CITY OF ALBUQUERQUE

December 22, 2016

Re: Drainage Control Ordinance (14-5-2-1) and NPDES CGP Violations for Erosion and Sediment Control

CONSTRUCTION FENCE/SILT FENCE SECTION
SCALE: 1" = 2'-0"
(OPTIONAL)

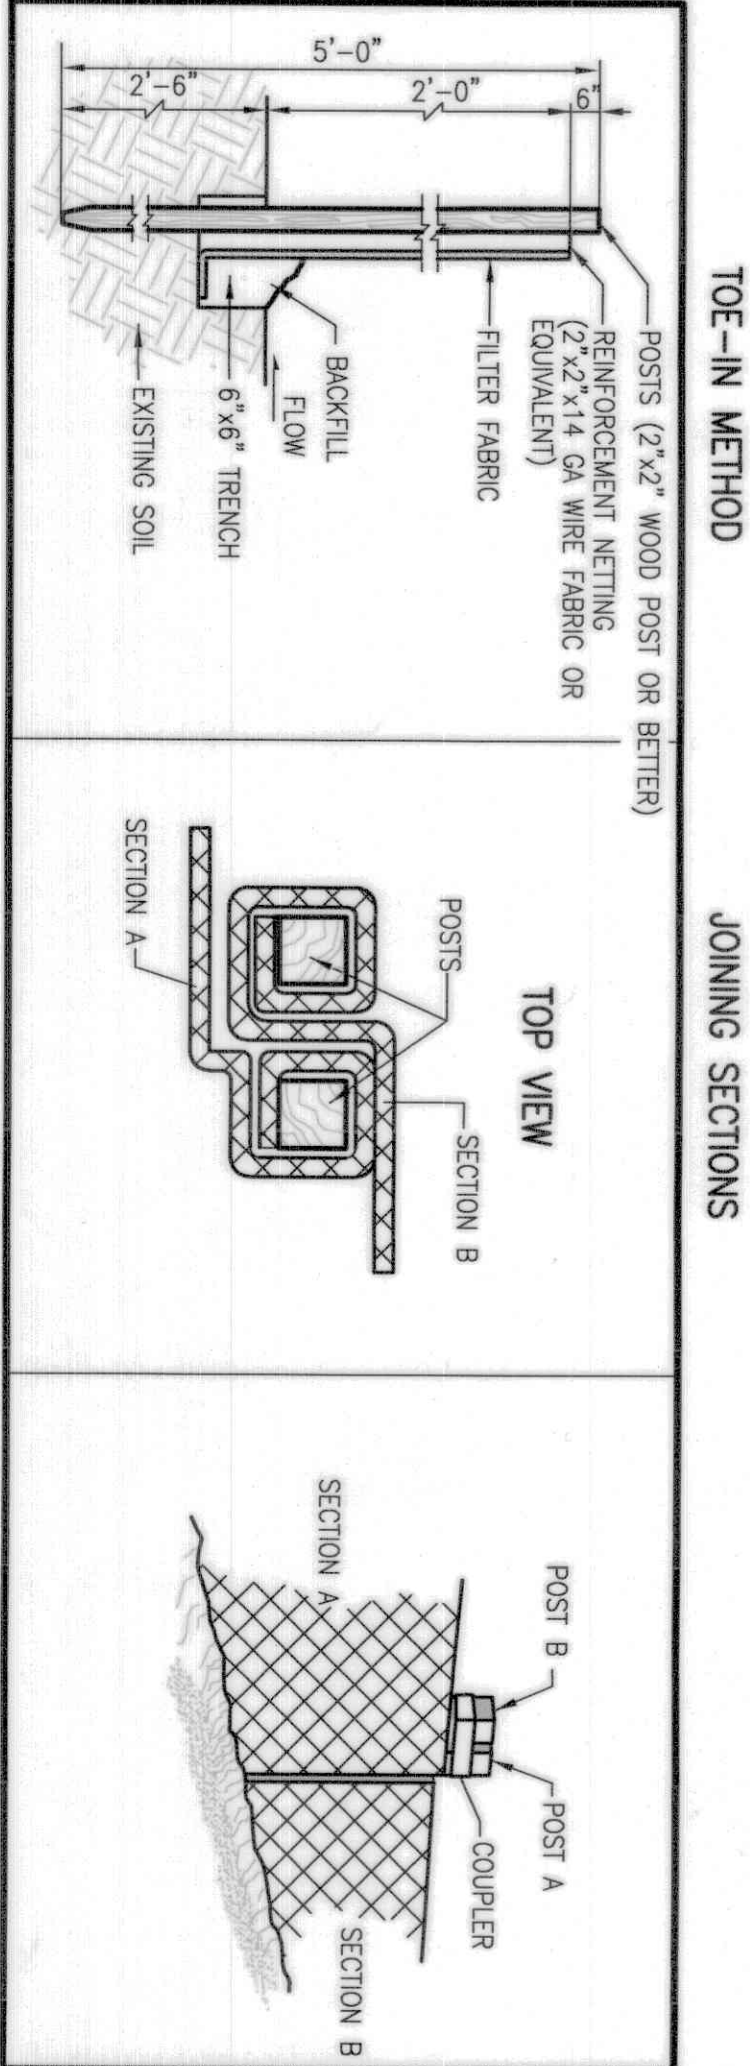
Sediment in gutter on 20th St. There is a gap in the silt fence in this location.

1. Remove sediment from 20th St., including the gutter and sidewalk.
2. Maintain/reinstall the silt fence along 20th street.
3. If you wish to continue to use the laydown/storage yard, install a track-out pad.

CONSTRUCTION ENTRANCE STABILIZATION
SCALE: 1" = 10'-0" HORIZ.
1" = 2'-0" VERT.

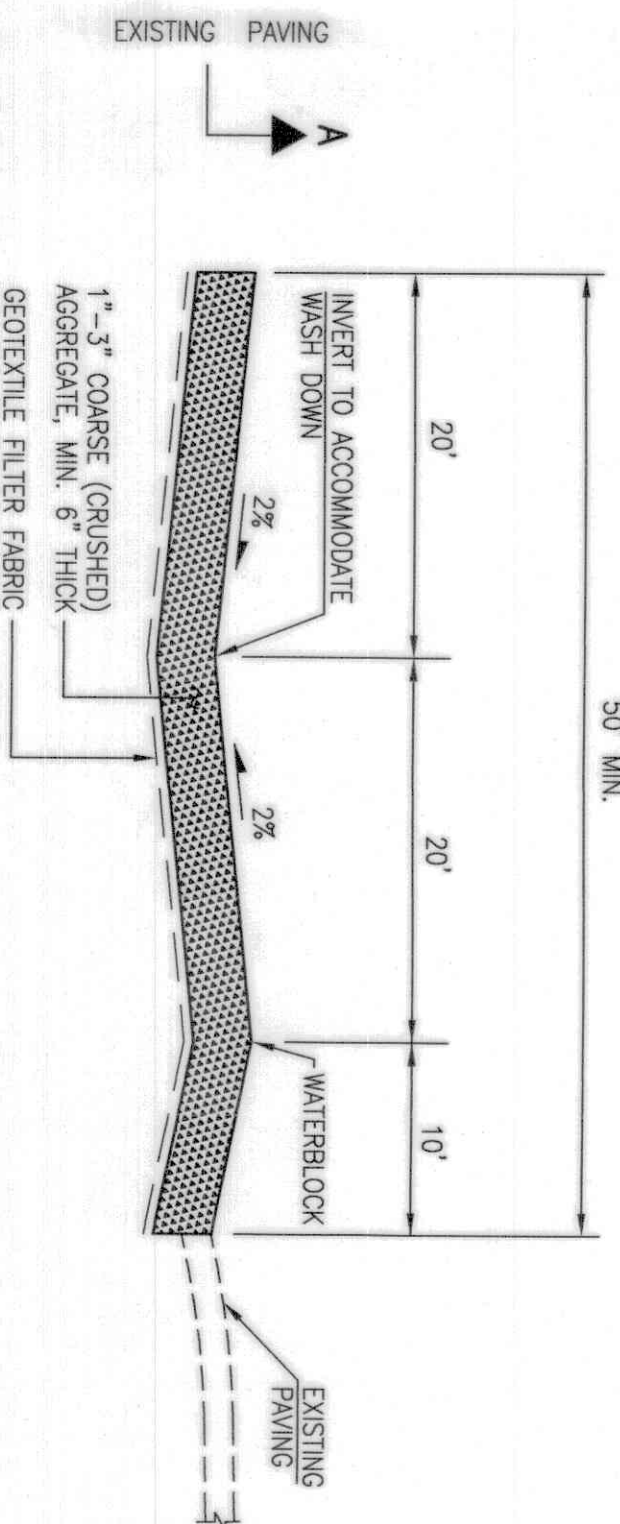
The source of the sediment was mostly caused from travelling to/from the laydown/storage yard to the building under construction and that the laydown yard did not have a track-out pad. See following photos.

Laydown yard, no track-out pad. Sediment on sidewalk and in gutter.
